# CITY OF ALBUQUERQUE

December 18, 2019

**Re: Eagle Rock Commons, Building D**  
**5501 Eagle Rock Ave NE**  
**30-Day Temporary Certificate of Occupancy**  
**Transportation Development Final Inspection**  
Engineer's/Architect's Stamp dated 9-23-09(AA)(C18D037H)  
Certification dated 12-13-19

sheet no:
S-1.0

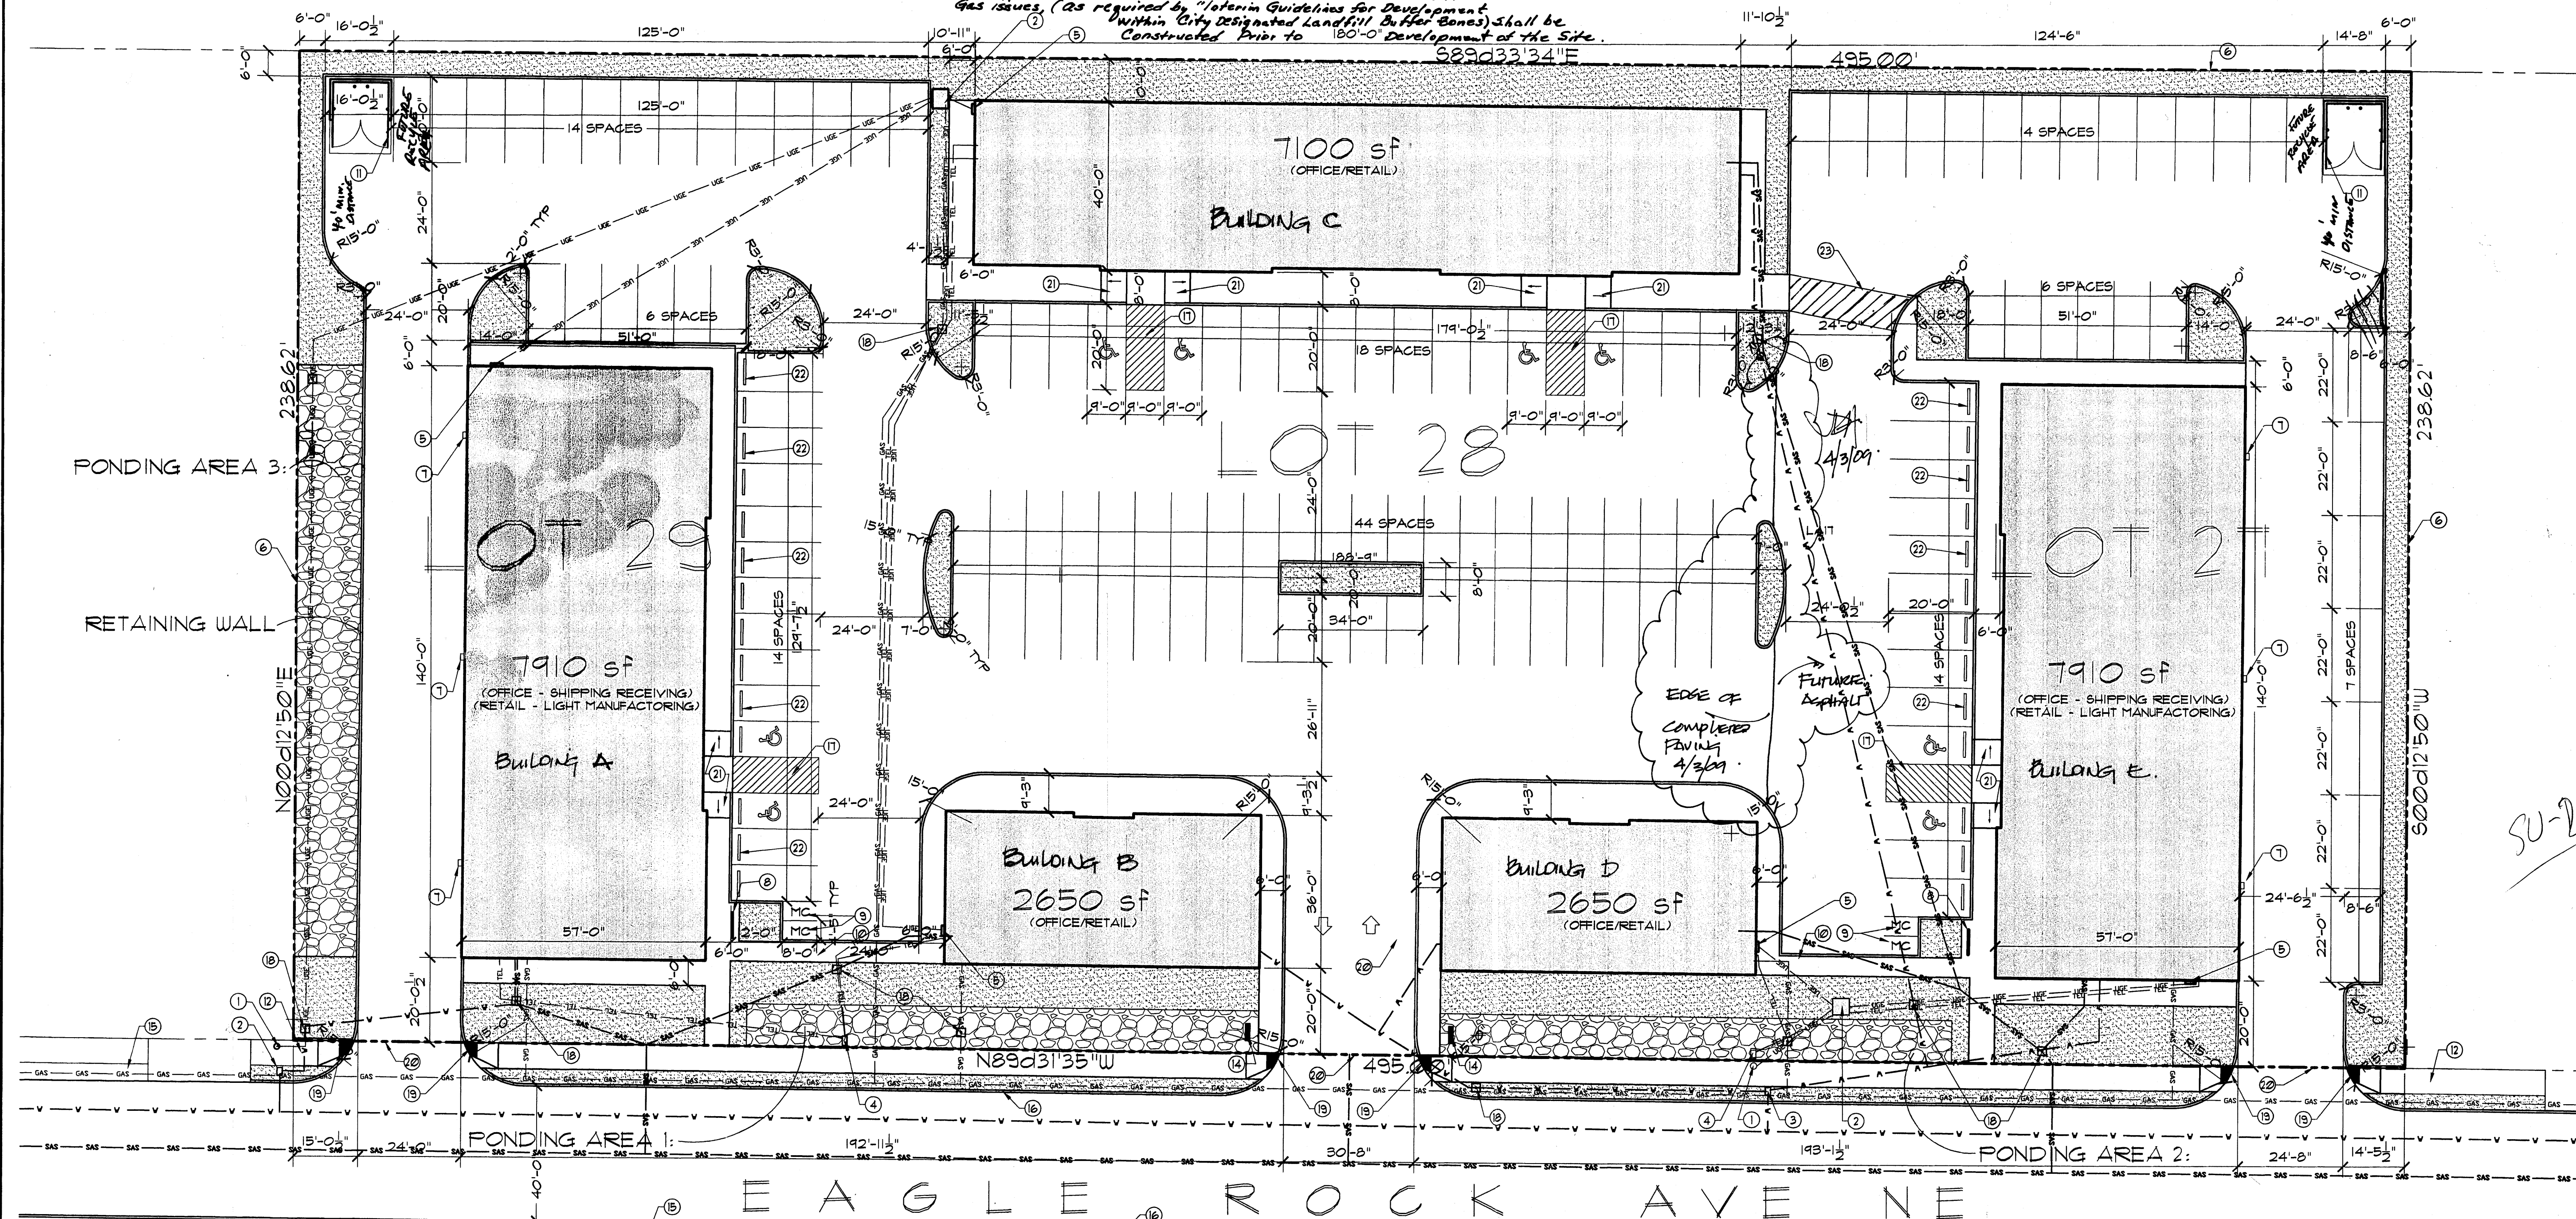
- ADA signs must be at least 60 inches measured to the bottom edge so that they are visible vehicles vehicles are parked in space.
- The ADA access aisles shall have the words **"NO PARKING"** in capital letters, each of which shall be at least one foot high and at least two inches wide, placed at the rear of the parking space so as to be close to where an adjacent vehicle's rear tire would be placed. (66-1-4.1.B NMSA 1978)
- The ADA accessible parking sign must have the required language per 66-7-352.4C NMSA 1978 **"Violators Are Subject to a Fine and/or Towing."** Please call out detail and location of HC signs.
- Please resend certification letter with engineer or architect stamp licensed in the state of New Mexico.
